From: Laura Gibbons <laura.Gibbons@arun.gov.uk>
Sent: 02 November 2021 15:23
To: Simon Davis <Simon.Davis@arun.gov.uk>
Subject: RE: Planning Consultation on: A/212/21/DOC

Formpave permeable block paving private parking area construction

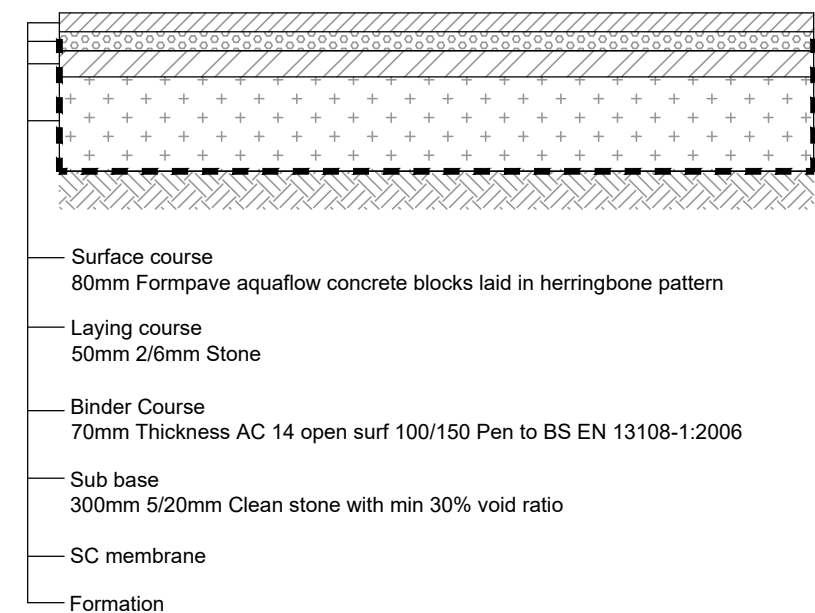
Quick response as I am on leave next week. The diffusers should not be located at the base of the permeable paving, the strategy was to drain hard surfaces via infiltration but to provide these with overflows to the network.

Formpave Diffuser tank construction

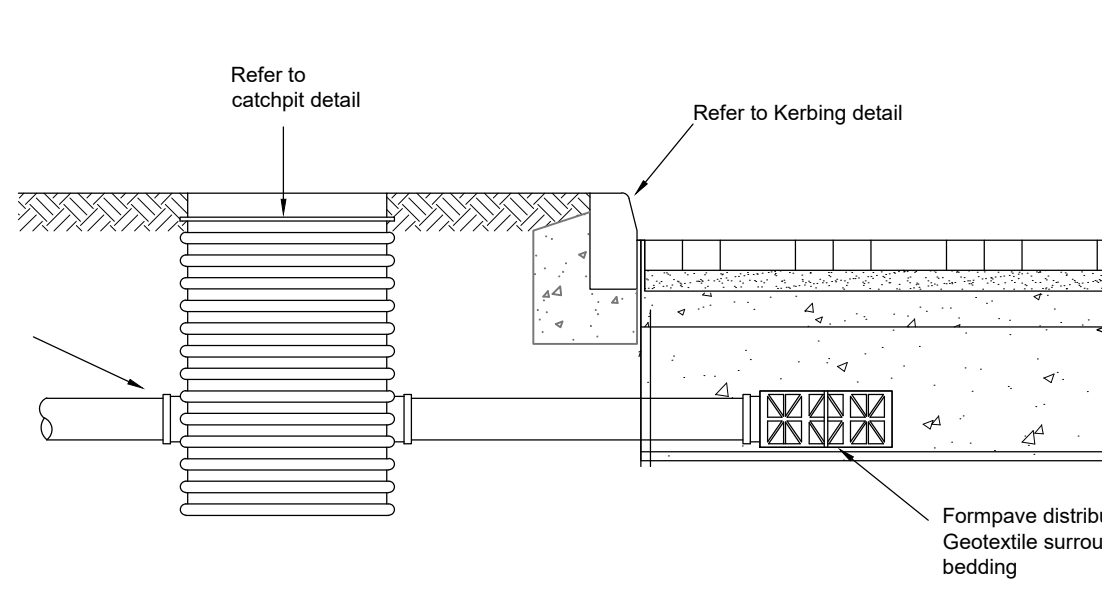
- It appears that there are some errors with the levels stated, please can the applicant review to ensure any typos are corrected to ensure that diffusers are located above formation level and a gravity connection from paving areas to the surface water drainage network can be achieved. The construction detail drawing implies that diffusers are the inlets to the permeable paving and that fin drains are proposed as outlets. However the arrangement of the diffusers and the levels stated on the layouts imply that the diffusers are actually being used as collectors at the base of permeable paving. My understanding is that the permeable paving is meant to infiltrate with high level overflow to the network, therefore levels should be revised so that the diffusers/ collectors are not set at the very base of the sub-base - I've revised the details to include the diffuser unit which is the Formpave diffuser unit detail used on site.
